WEST SUSSEX COUNTY COUNCIL CONSULTATION

TO:	Arun District Council FAO: Zac Denton
FROM:	WSCC - Highways Authority
DATE:	10 June 2019
LOCATION:	Land at Entrance to Waterford Gardens Horsemere Green Lane Climping BN17 5PQ
SUBJECT:	CM/18/19/PL Erection of 2 No 3 bed dwellings with off-road parking and associated landscaping
DATE OF SITE VISIT:	
RECOMMENDATION:	Advice
S106 CONTRIBUTION TOTAL:

drawing title:
Site Plan

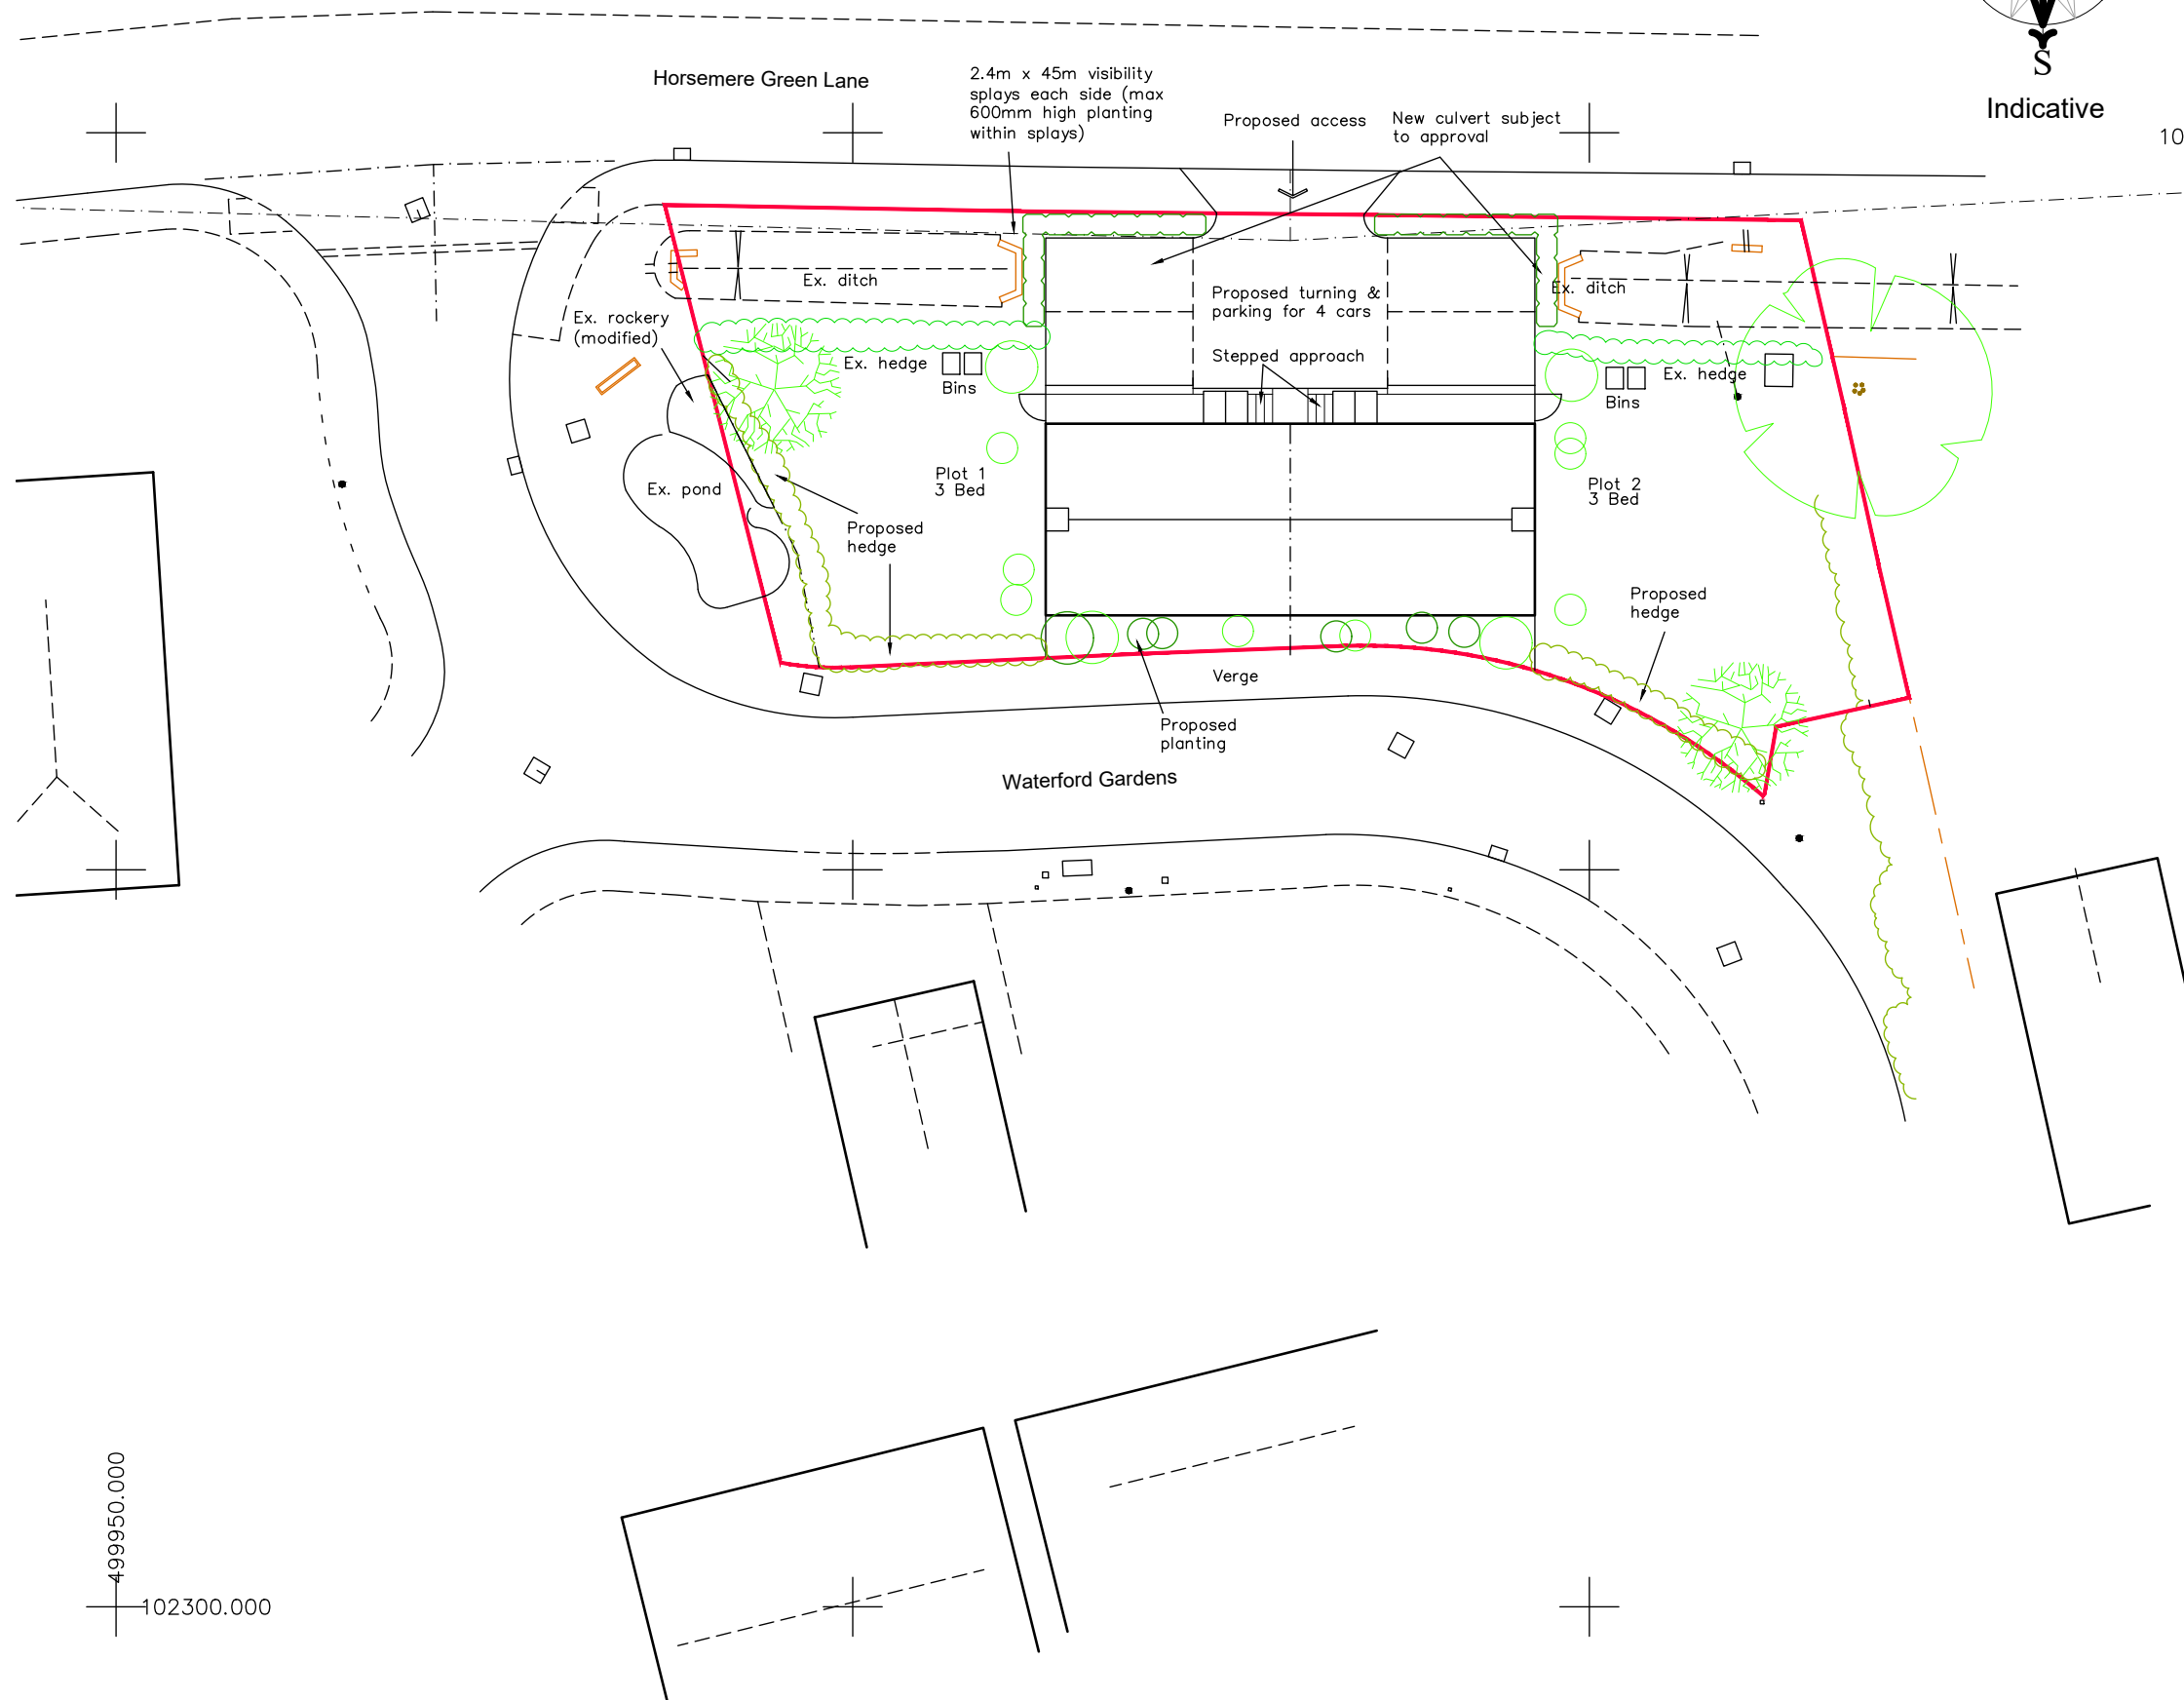
No part of the development shall first be occupied until Maximum achievable visibility splays of 2.4m x (Max Achievable) shown on the plans submitted to the Local Planning office have been implemented. These splays shall thereafter be retained at all times.

No part of the development shall be first occupied until the car parking has been constructed in accordance with the approved site plan. These spaces shall thereafter be retained at all times for their designated purpose.
